**From:** planning@cherwell-dc.gov.uk  
**Sent:** 08 April 2020 16:03  
**To:** Linda Griffiths  
**Subject:** New comments for application 19/01037/REM

New comments have been received for application 19/01037/REM at site address: OS Parcels 6741 And 5426 West Of Cricket Field Nor Wykham Lane Bodicote

PROJECT Bodicote			
DRAWING House Type Planning Drawing House Type: N107 & SH72 (Terrace) Floorplans - Sheet 1 of 2			
SCALE 1:100@A1	DATE Nov 19	AUTHOR IR	REV C
JOB NO. 7942	DRAWING NO. BOD.HT.025		
CHARACTER AREA Main Street

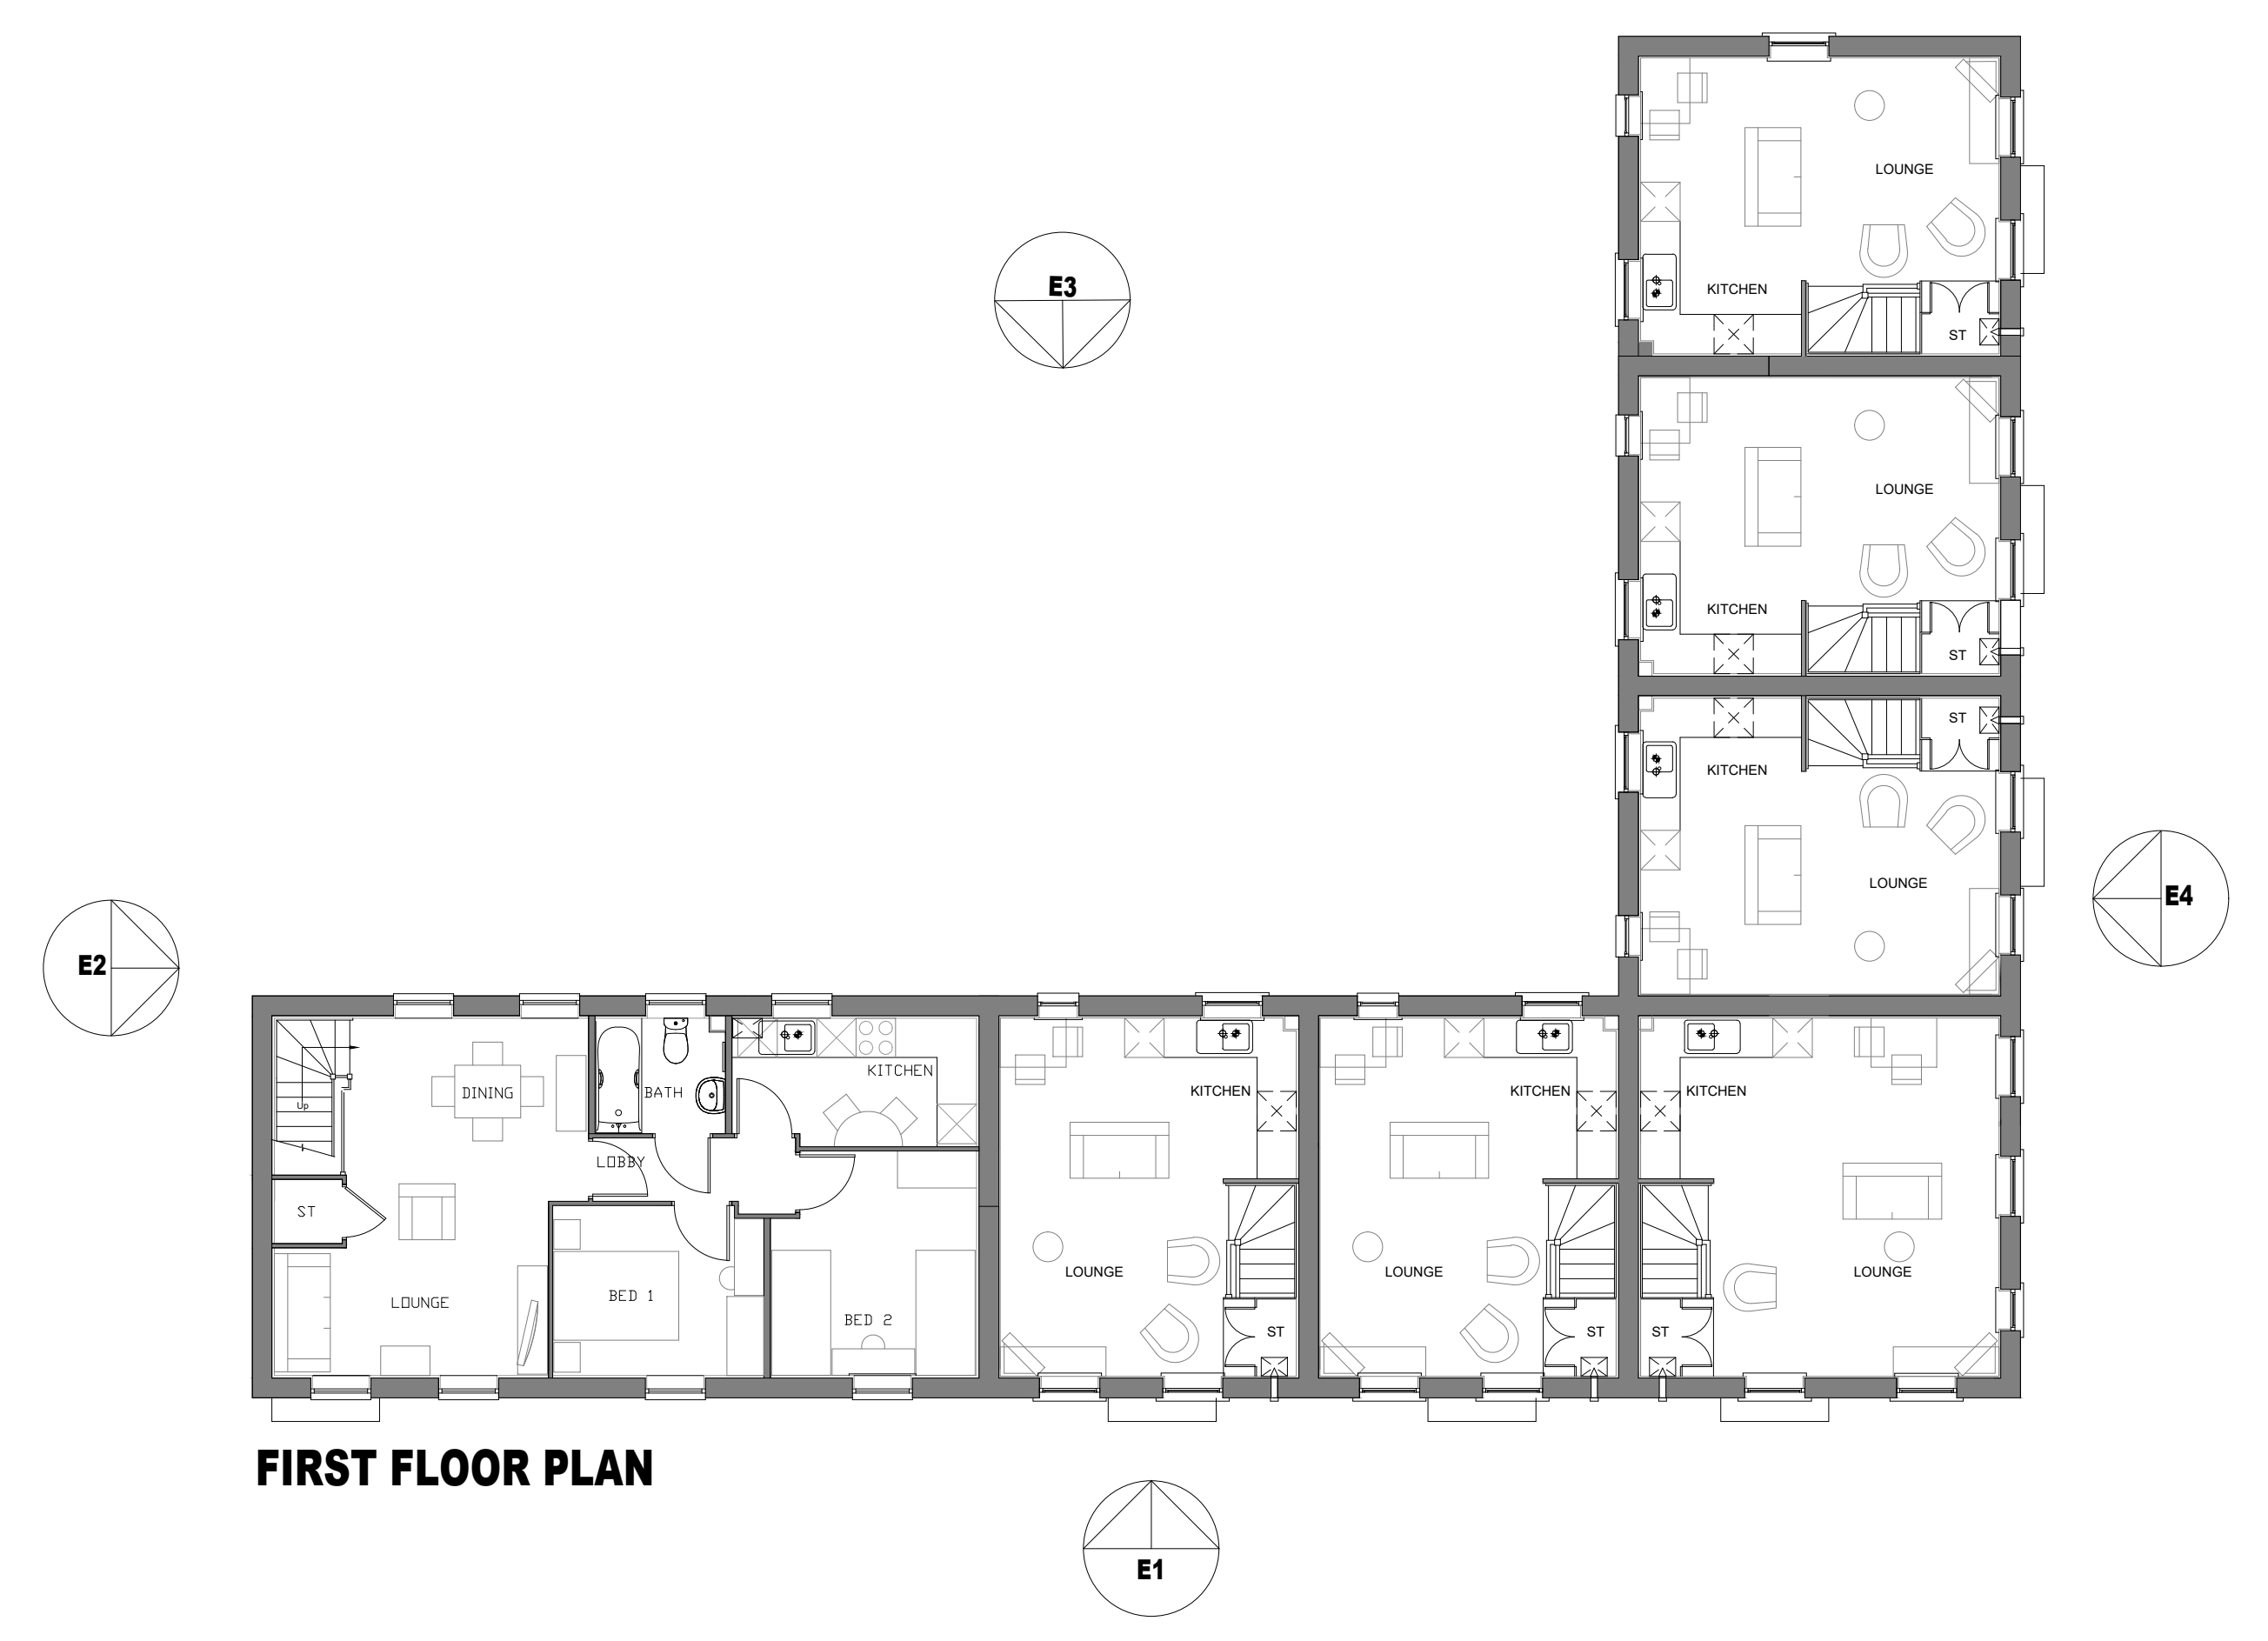
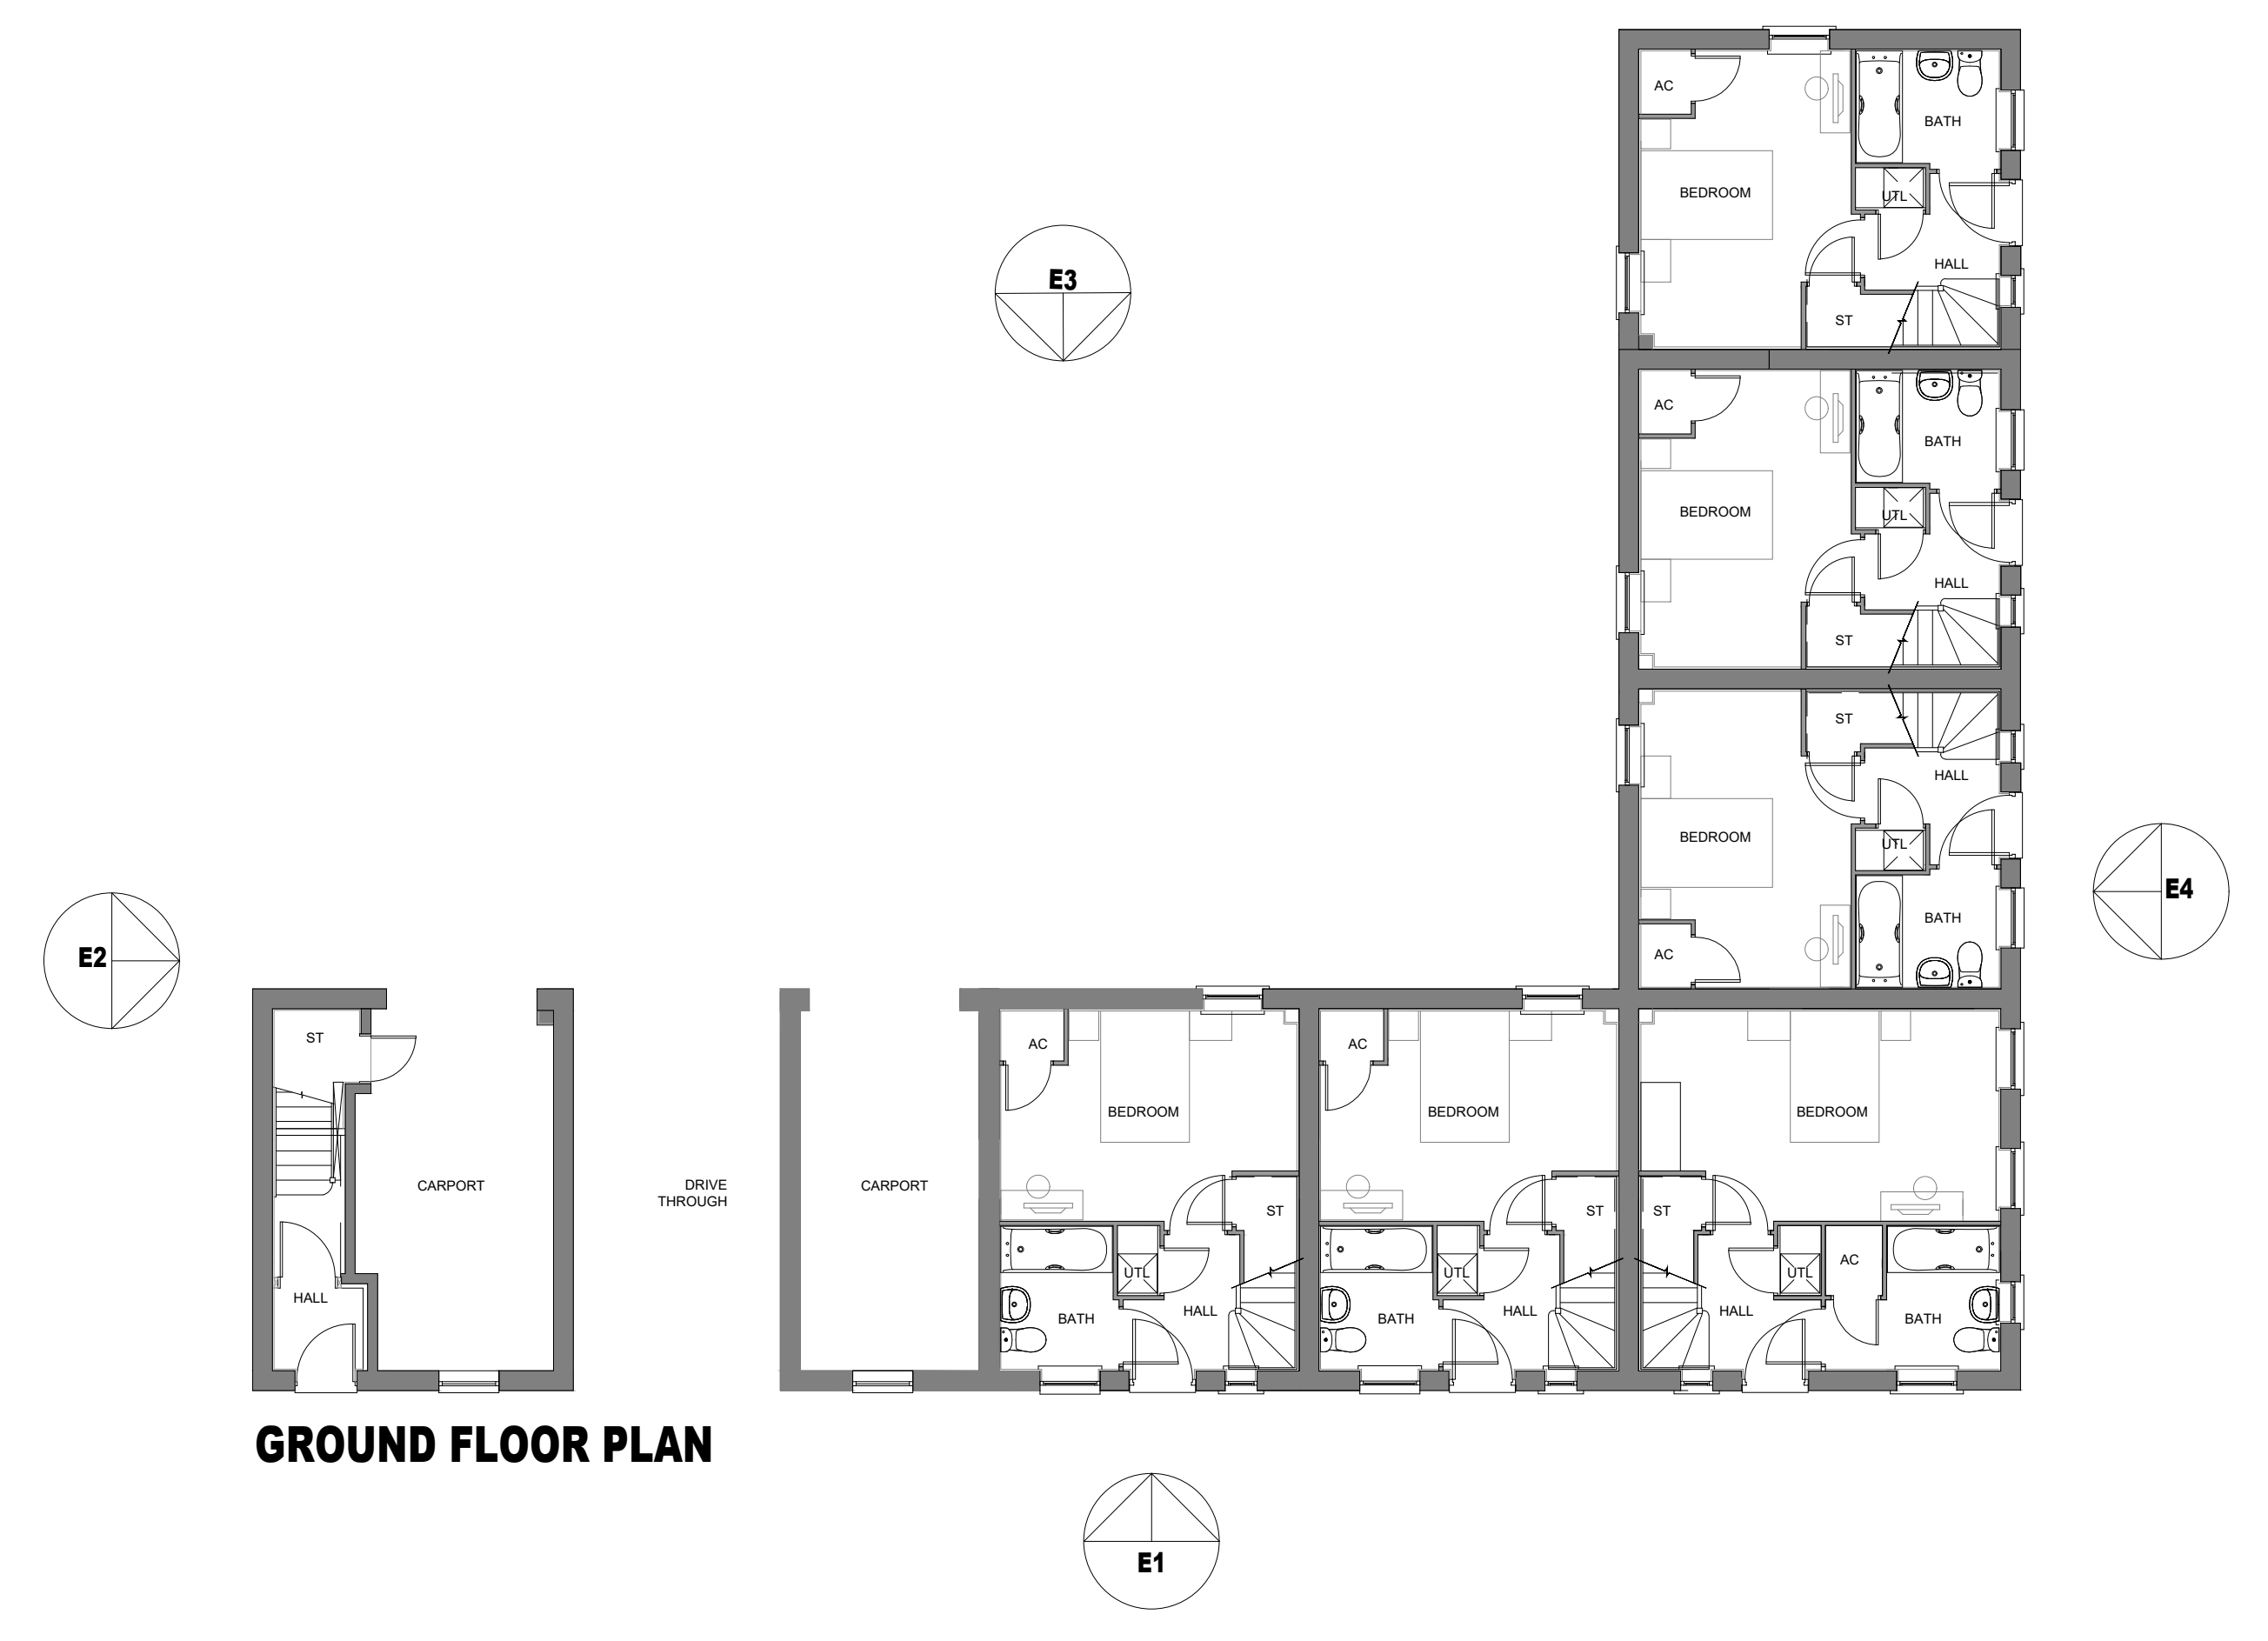
There are a considerable number of drawings for this application and it has not been straightforward to see exactly what mix is being offered for the affordable element. The clustering is generally ok, although in one area, with Plots 7-12, 18 and 20-29 clustering of units is over the desired number. The affordable housing should be tenure blind but it can be distinguished by rear parking courtyards which are not provided for market housing.
